OBSERVATION/SUBMISSION TO PLANNING APPLICATION

Case Reference: 324113

To: An Coimisiún Pleanála
64 Marlborough Street
Dublin 1
D01 V902

Re: Observation to the proposed development of open-cycle gas turbine (OCGT) and generator with ancillary equipment.

Purpose		PLANNING			
Title		SITE ACCESS SIGHTLINES			
Original Scale	Design/Drawn	Checked	Authorised		
SHOWN at A1	PS	ND	AJB		
Date	Date	Date	Date		
01.12.25	01.12.25	01.12.25	01.12.25		
Status	Drawing Number	Rev			
A2	PEK3-ATK-ZZ-01-DR-CE-901200	0

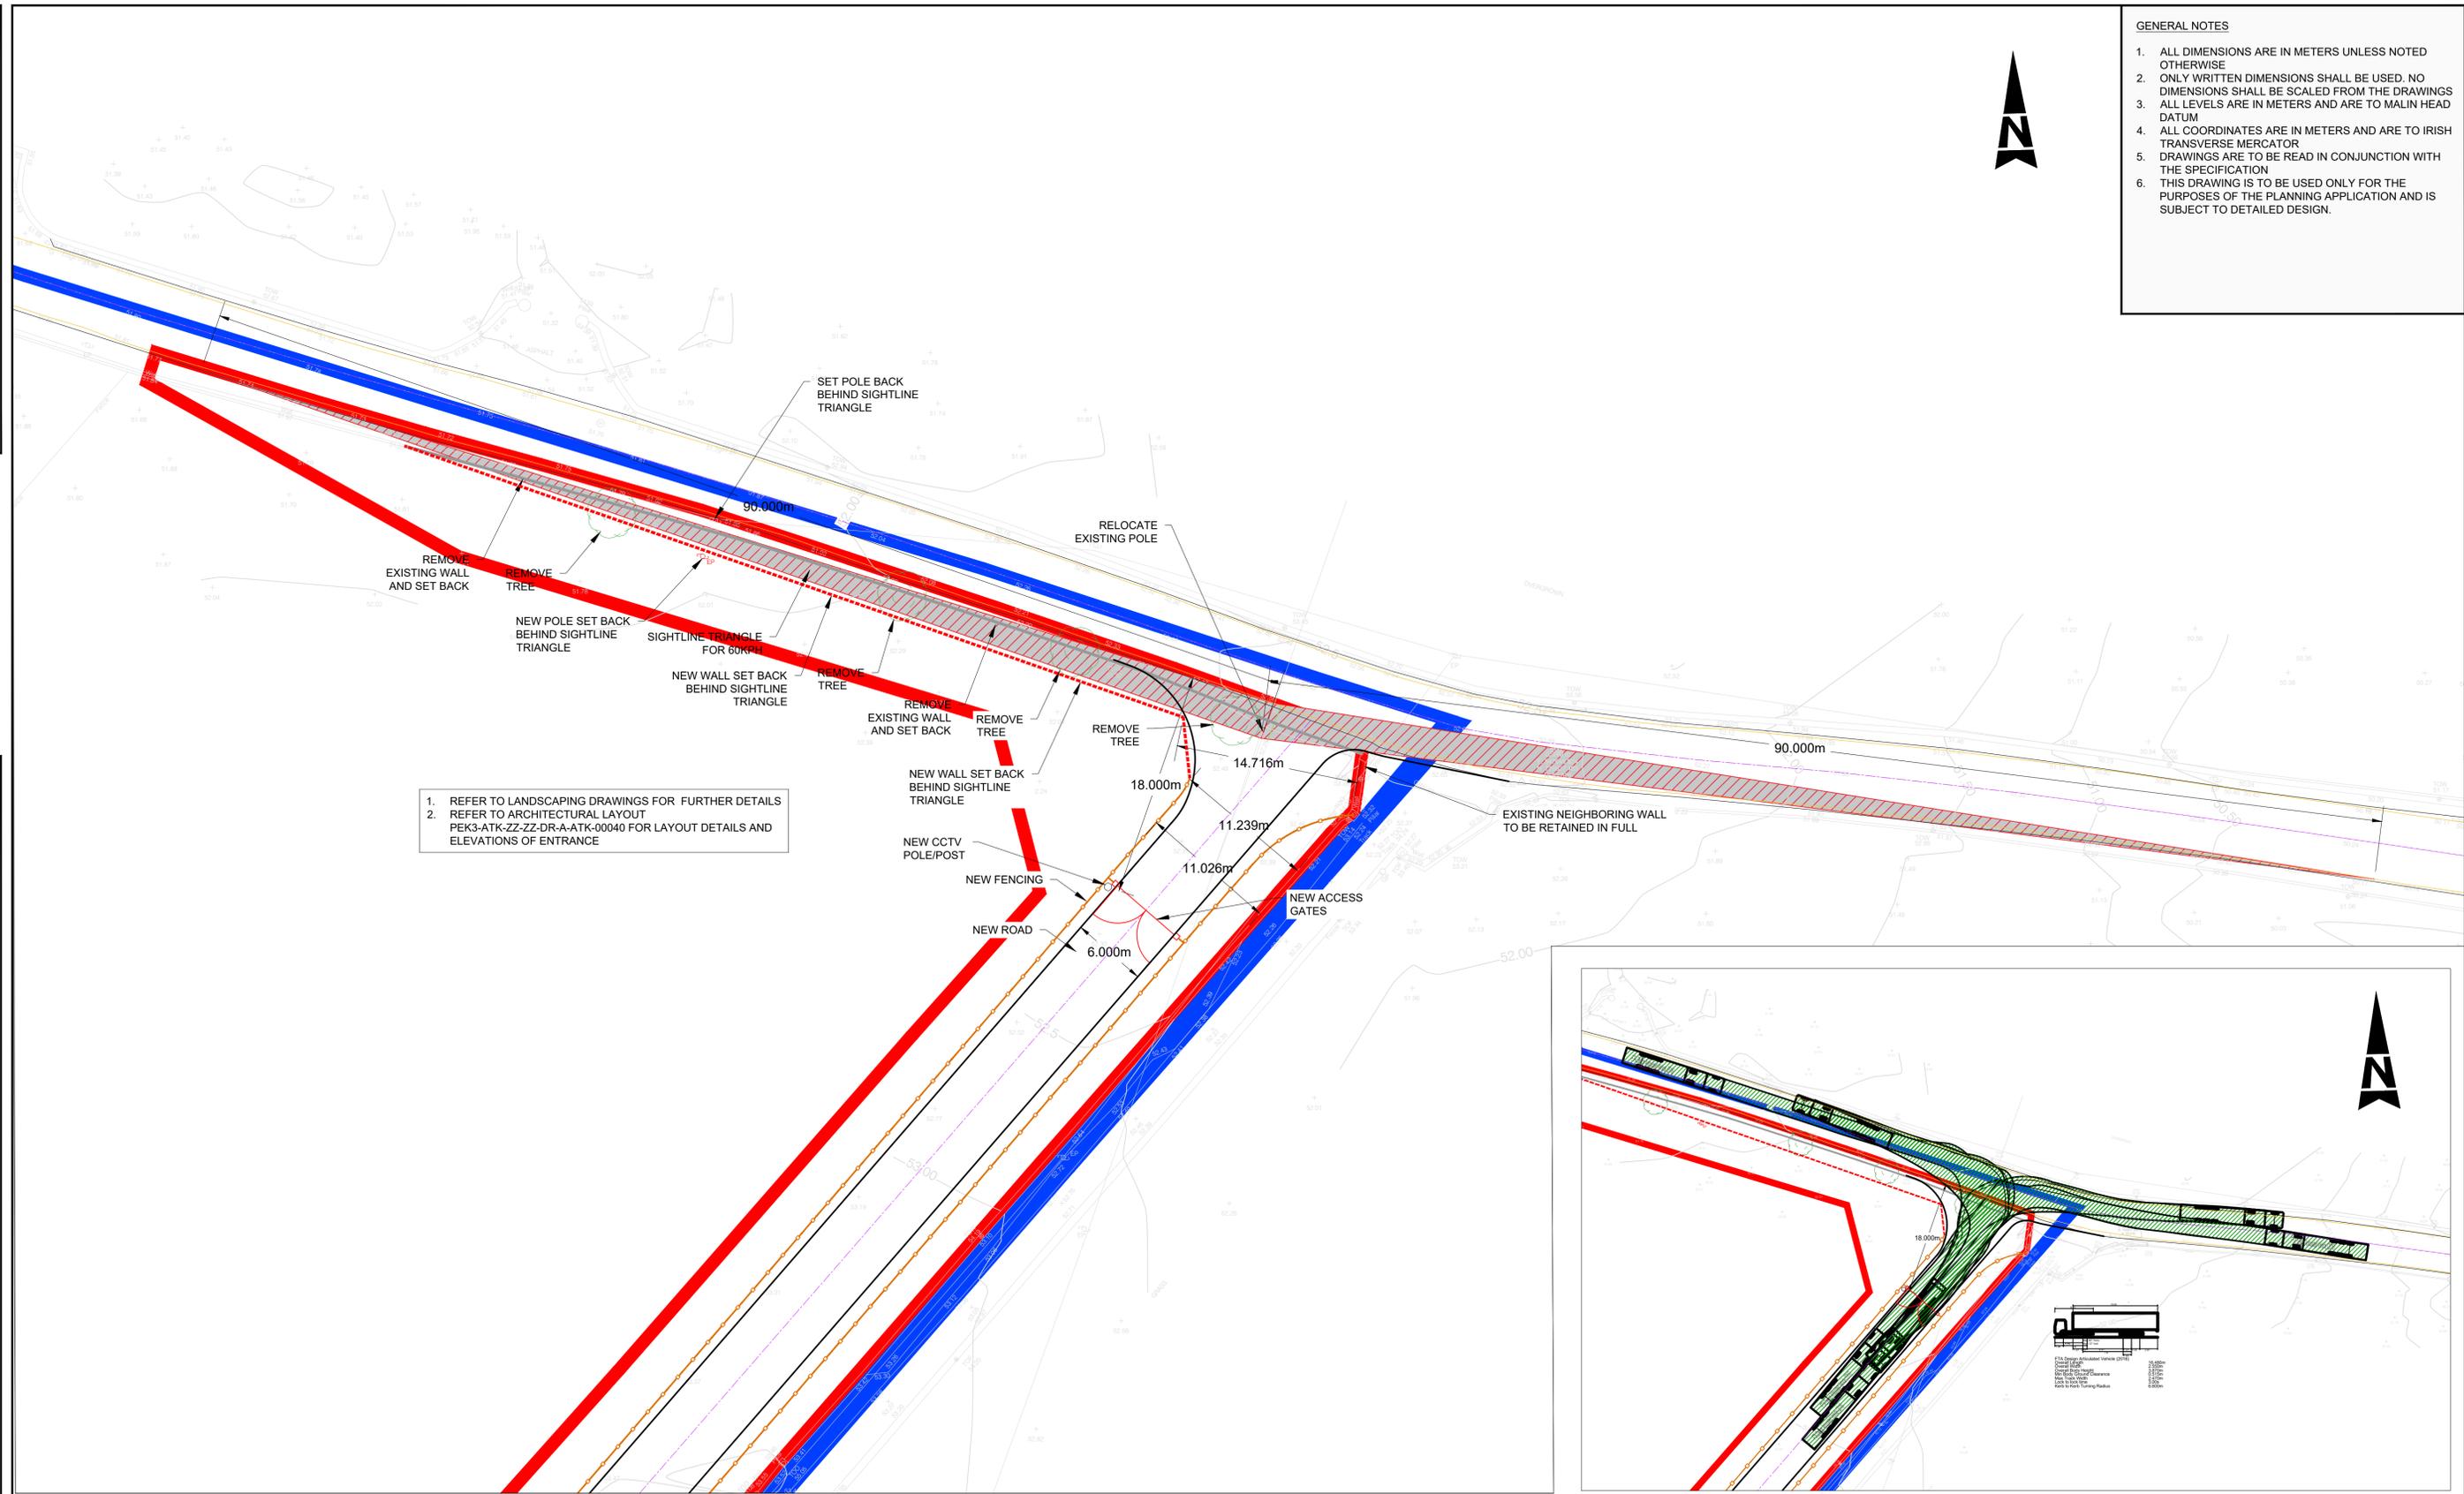
Positioning the site entrance at this location on the L3103 introduces extreme risk to road users. This treacherous section of the road is entirely devoid of a hard shoulder and is physically too narrow for two HGVs to pass one another safely. Furthermore, severely compromised sightlines caused by blind dips and sharp corners make this access point highly perilous. It is imperative that these severe, compounding traffic hazards are urgently mitigated before any development is permitted.
